CITY OF ALBUQUERQUE

Response to comment responses by Curtis
Cherne P.E., COA, 11-8-24

**Re: Central and Unser Development
Traffic Impact Study (K10D063)**
DRAFT dated June 25, 2024
Via email jroberts@tierrawestllc.com

ENGINEER'S SEAL	7707 W CENTRAL ALBUQUERQUE, NM	DRAWN BY LN
	CONCEPTUAL SITE PLAN	DATE 12-09-21
		DRAWING 2021007_SPE
RONALD R. BOHANNAN P.E. #7868	TERRA WEST, LLC 5571 MIDWAY PARK PL NE ALBUQUERQUE, NEW MEXICO 87109 (505) 858-3100 www.tierrawestllc.com	SHEET # C1
		JOB # 2021007

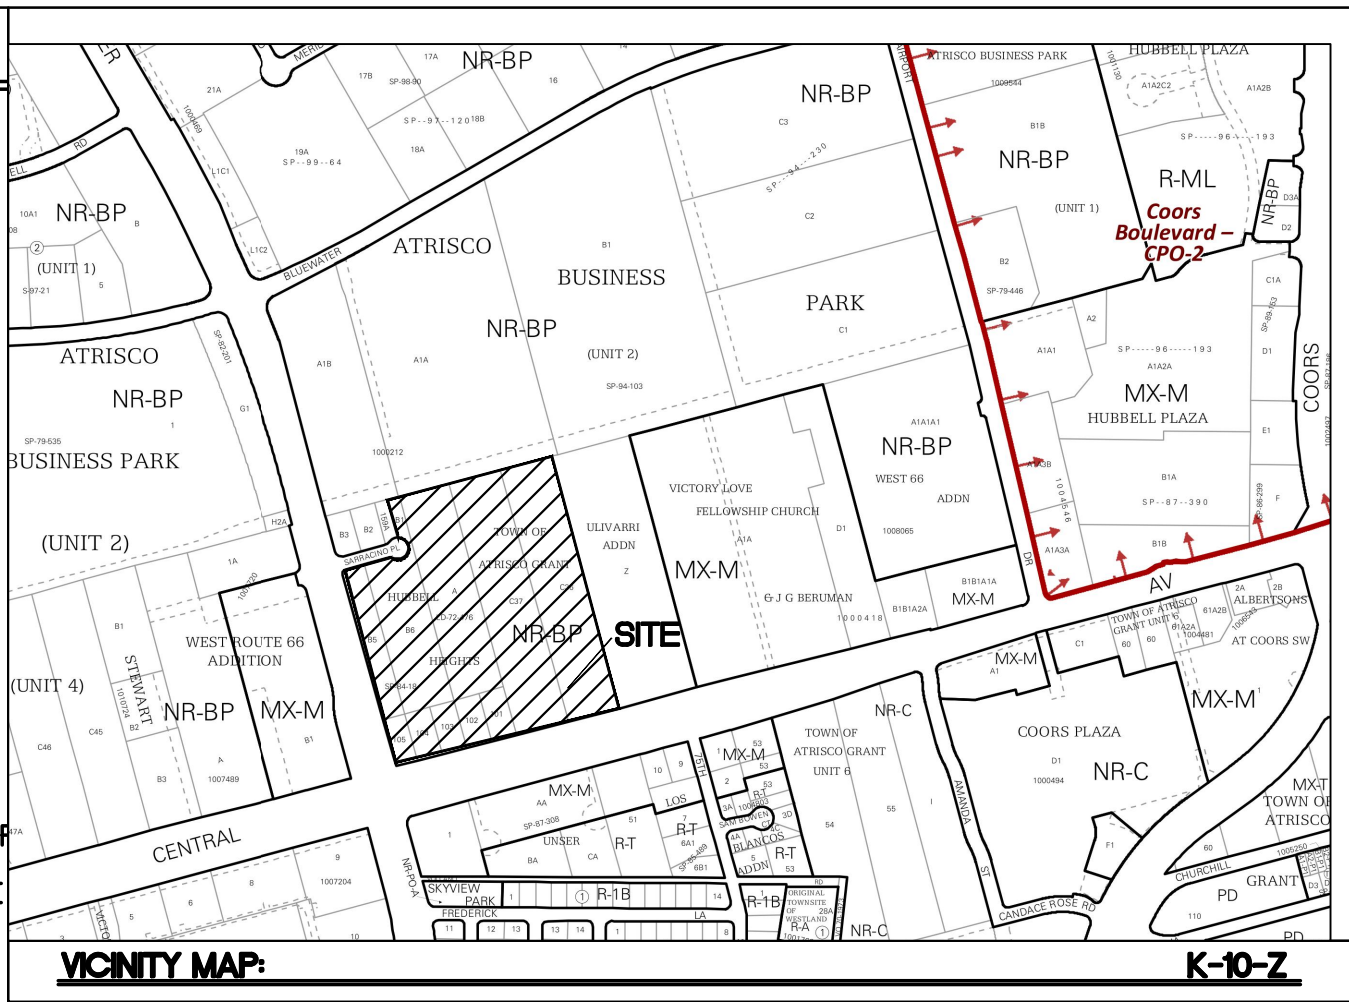
4. There are too many driveways/conflict points proposed on Central Ave. It is preferable to have just one access on Central Ave as discussed in #1 above.

9. Show the Central driveway design in more detail.

Response: The number accesses to the development have been reduce to 4 instead of 6:

1. Driveway "A" - Sarracino Pl/Unser (Full Access, Existing, Signalized)
2. Driveway "B" (Formerly "E") - Central Ave./Driveway "B"(Full Access, Proposed, Unsignalized), Driveway D
3. Driveway "C" - Central Ave./Driveway "C" (Right-in/Right-out, Proposed, Unsignalized)
4. Driveway "D" - Central Ave./Driveway "D" (Right-in/Right-out, Proposed, Unsignalized) Driveway B, Right-in Only

Driveways per revised site plan edited 11-8-24. See attached.
